KITITAS COUNTY

DEPARTMENT OF PUBLIC WORKS

MEMORANDUM

TO: All Staff
FROM: Public Works Plan Review Team
DATE: May 25, 2022
SUBJECT: BL-22-00013 Coe & Coe

# RECORD OF SURVEY

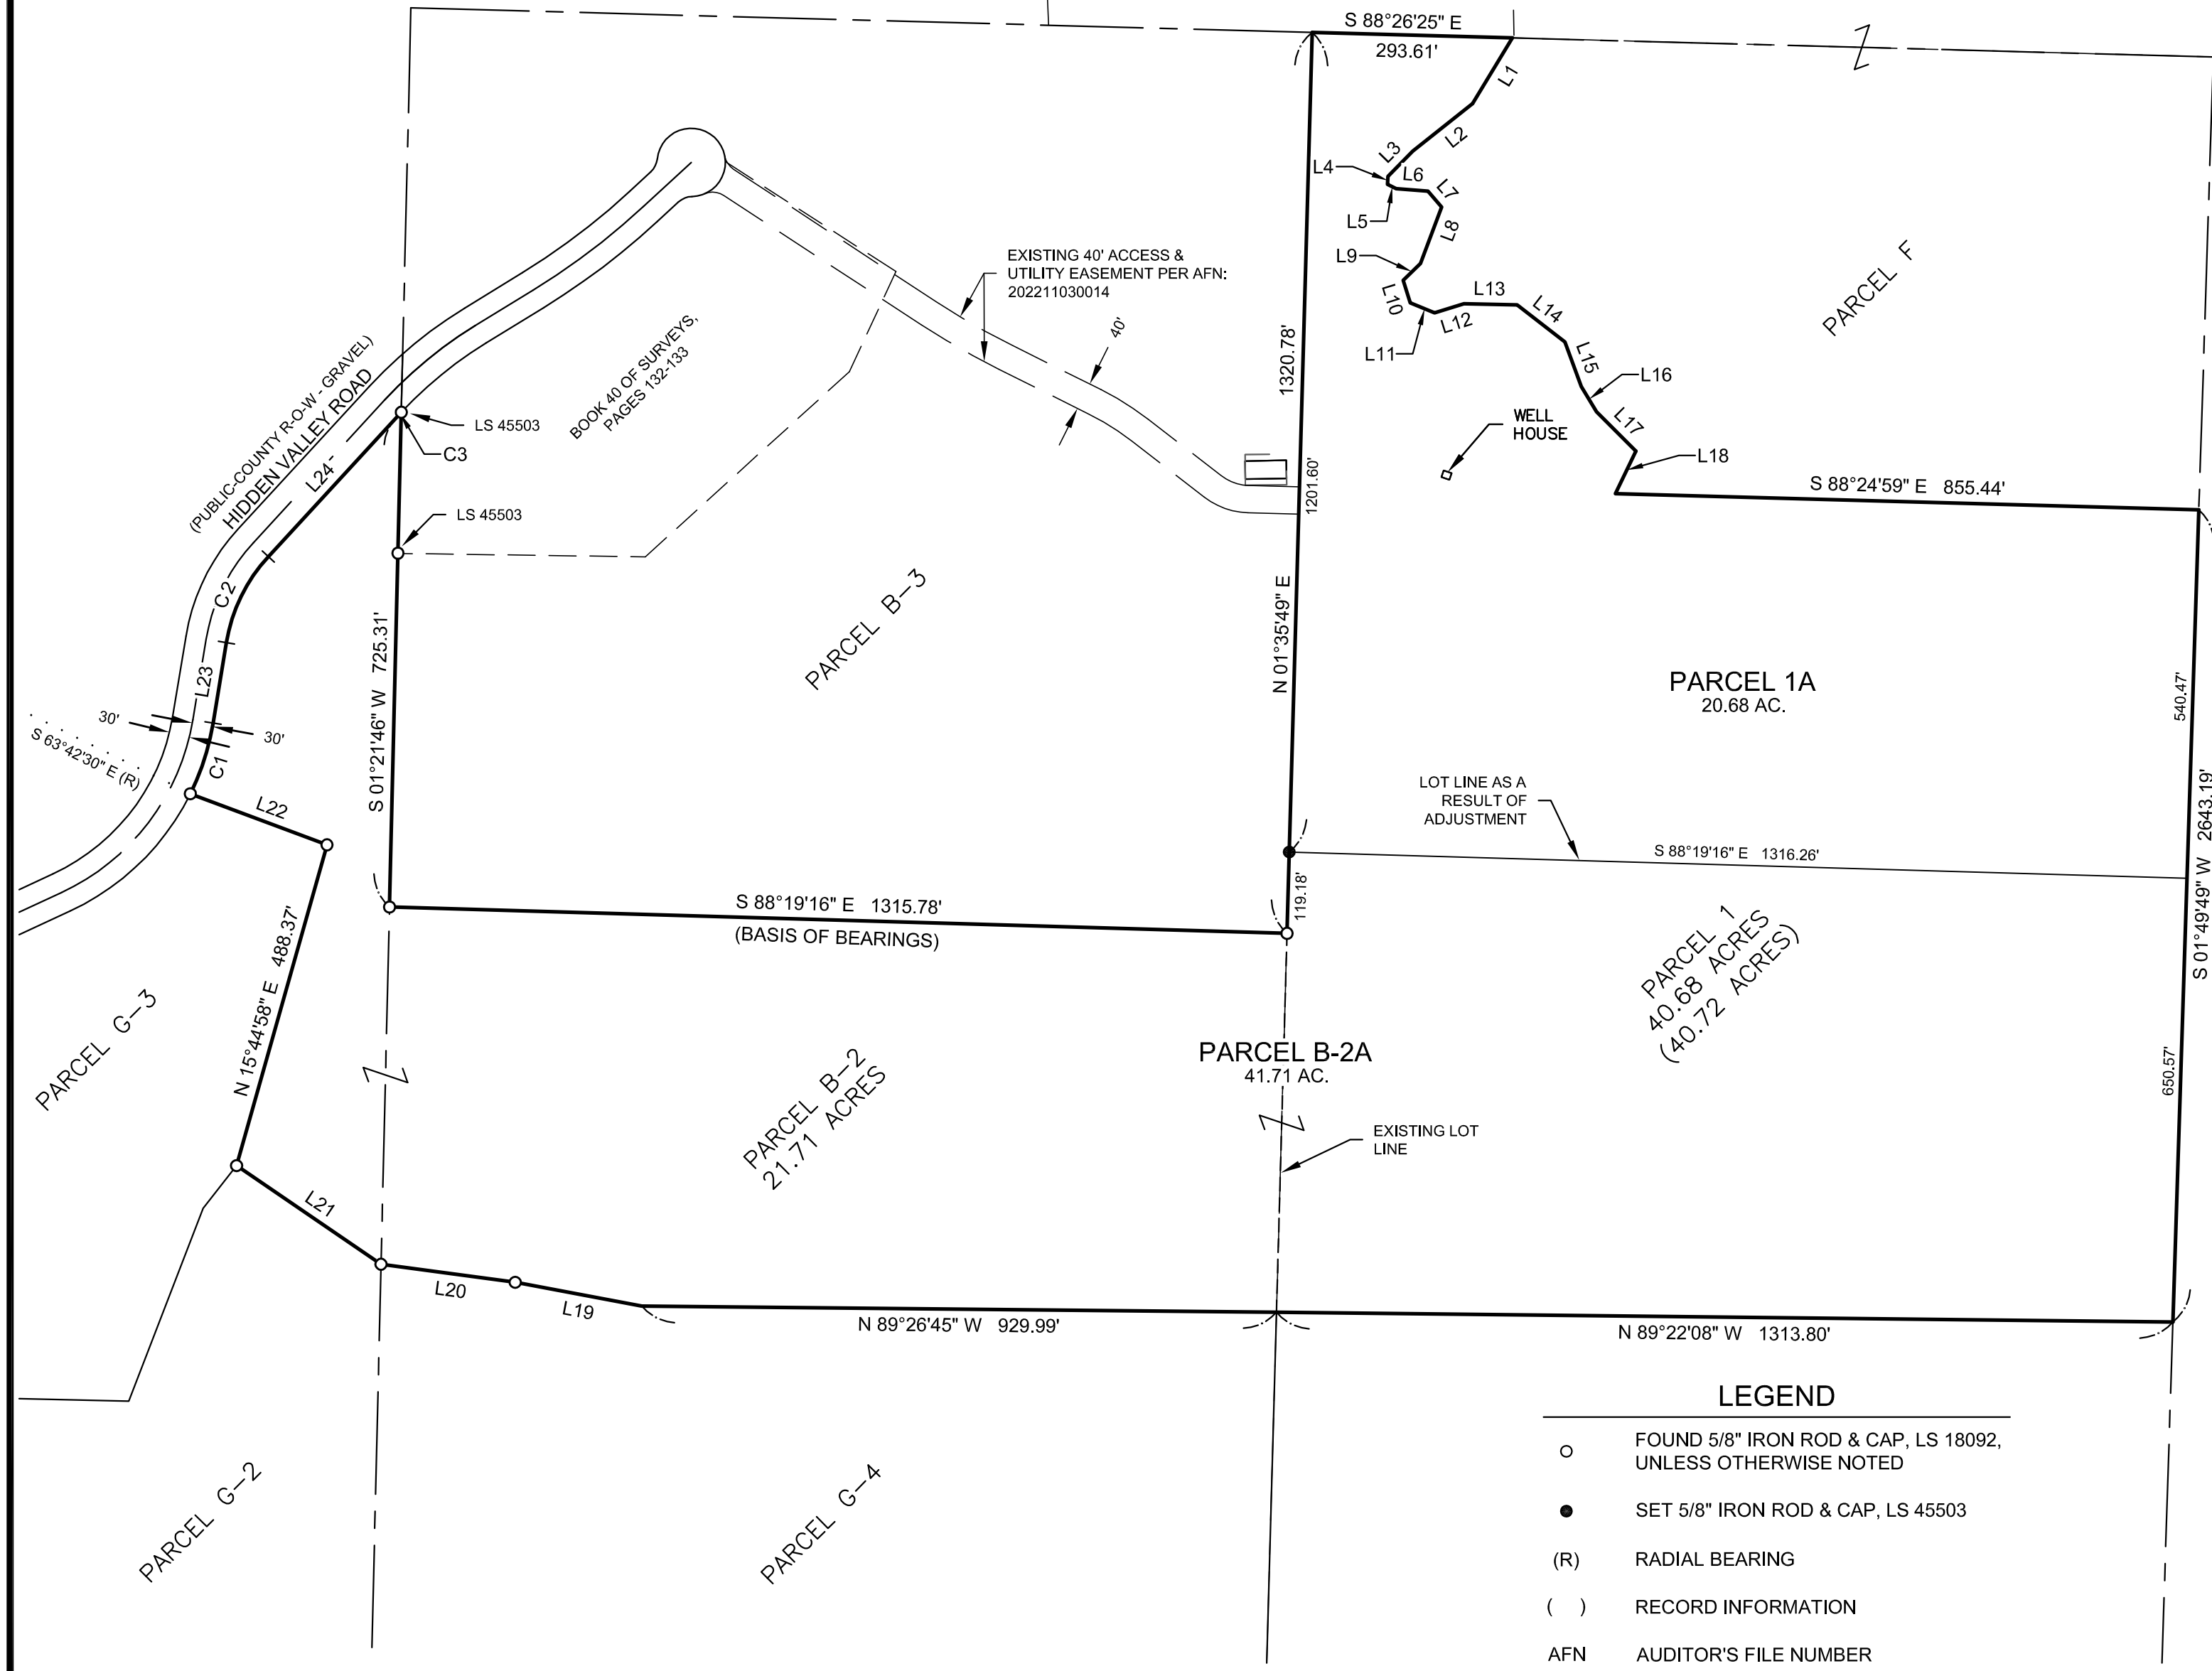
1. Bearing is missing on map for northern property line of parcel 1A.
2. Reference note containing purpose of survey and the application number are missing (KCC 16.10.020(1))
3. Basis of Bearing is not identified (WAC:332-130-050(1)(b)(iii))
4. Roadway ownership, surface material, bearings and distances are not identified on the map.
5. Legend is missing from map.
6. Text size appears to be smaller than the 0.08" minimum.

RECORD OF SURVEY

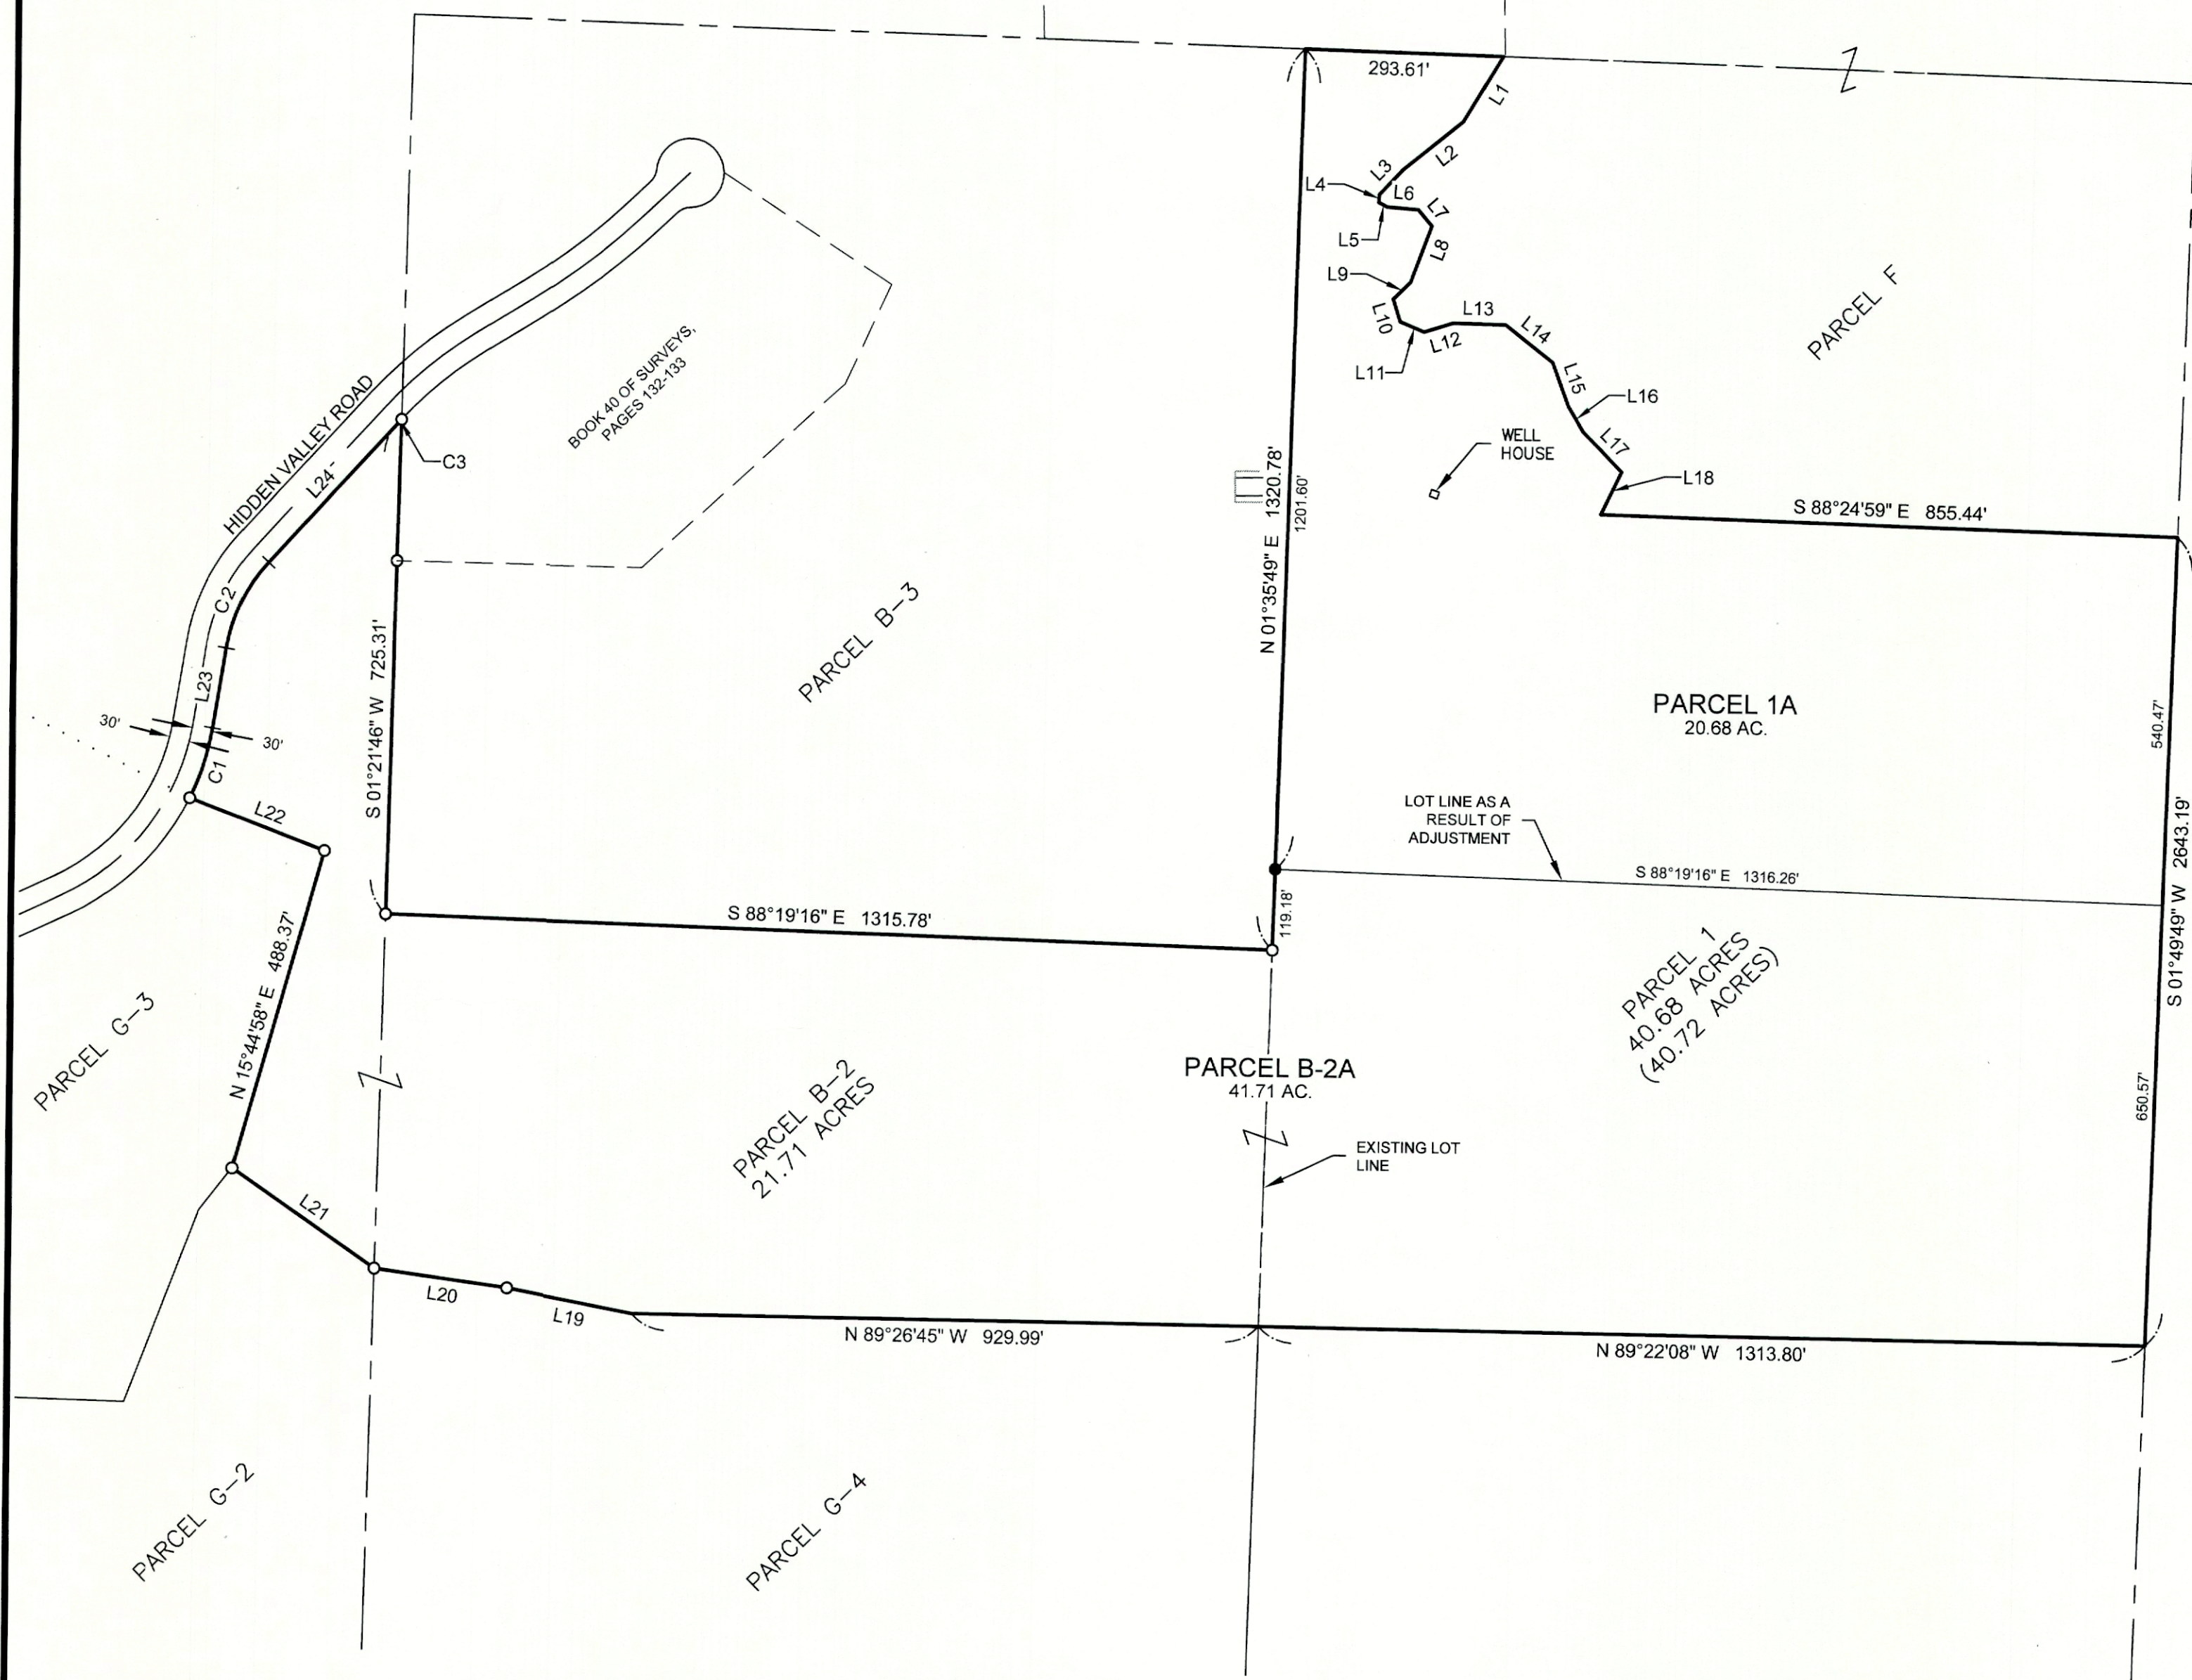
- a. Please provide proof of legal access in the form of an easement or certified road for Parcel 1A (20.68 AC).
